Application No: K/17/22/PL
Site Address: Panorama Golden Acre Kingston BN16 1QP
Description of works: Conversion of existing 2 No flats into 1 No dwelling, single-storey extension with a sloping roof, new porch on ground floor, conservatory at first floor and roof extension, replacement of existing windows, doors and roof tiles. This site is in CIL Zone 4 and is CIL Liable as new dwelling.

Thank you for your internet representation made on 28th July 2022 which has been recorded as an objection with the comments as follows:

Note: Elevations include proposals approved under K/40/20/HH (27th November 2020)

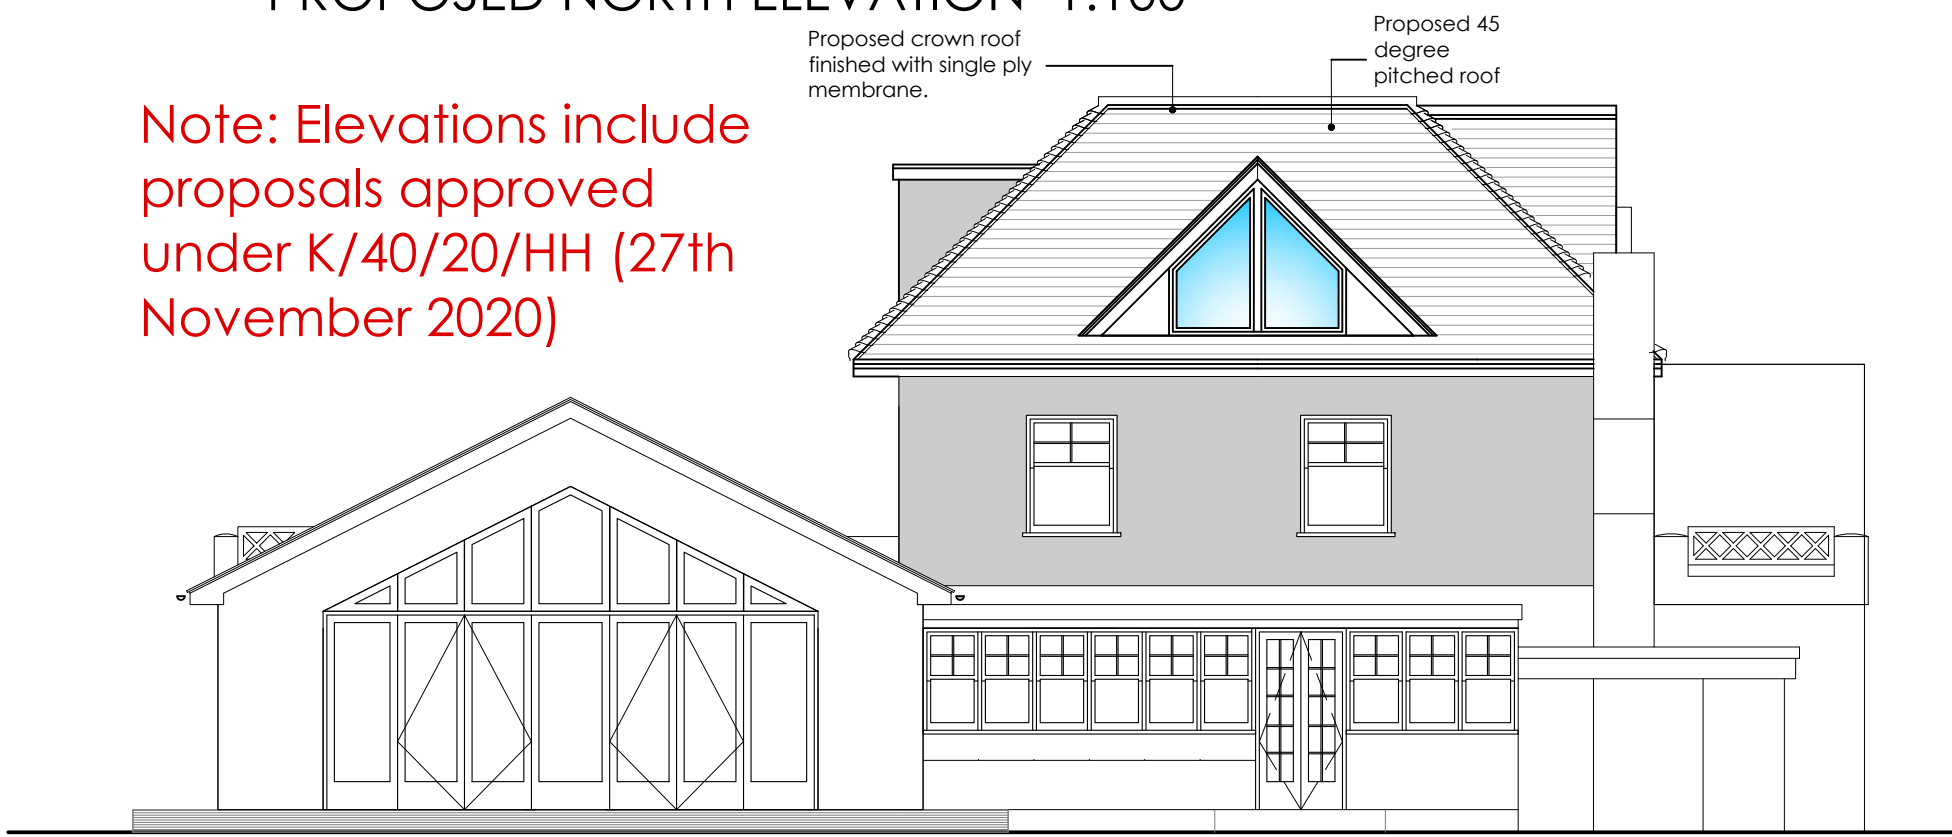
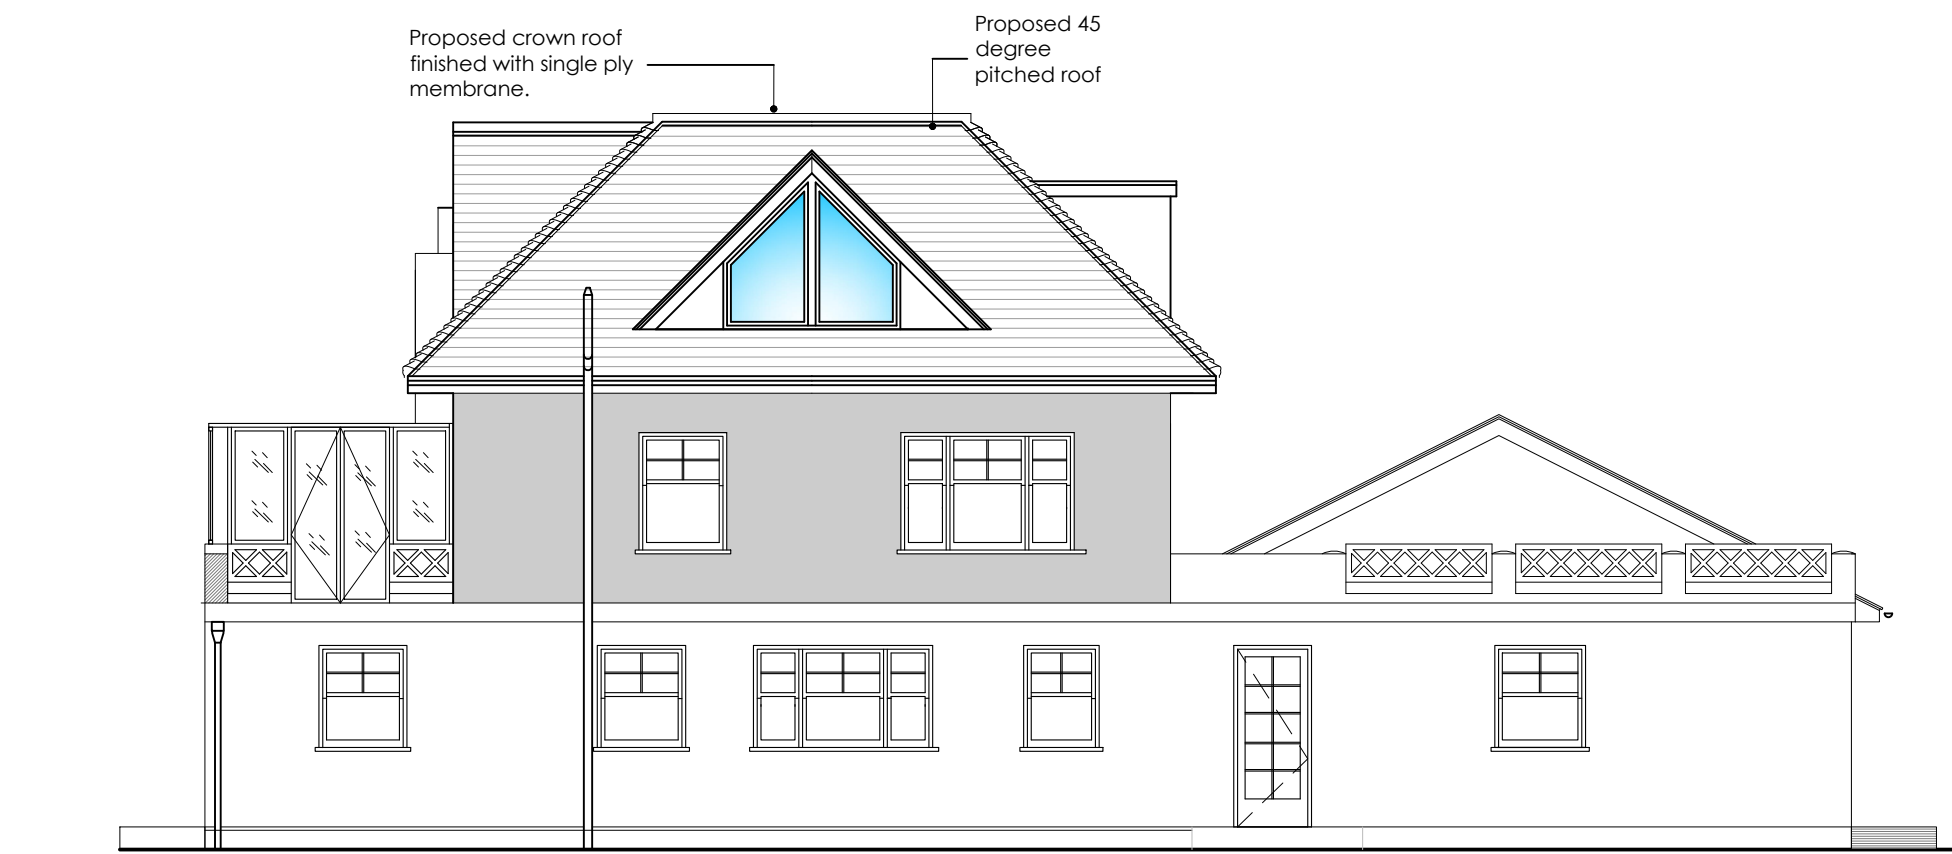
2. There needs to be an understanding of the impact the additionality of this development will have upon us. With the enlargement of the roof space and raised ridge height and the inclusion of both the east elevation and north elevation windows within the roof to create the second floor will lessen our privacy even further. The northerly elevation roof window will look directly down into our main bedroom that is on the south west corner of our property, let alone the eastern elevation roof windows that will expose the totally of our rear garden with
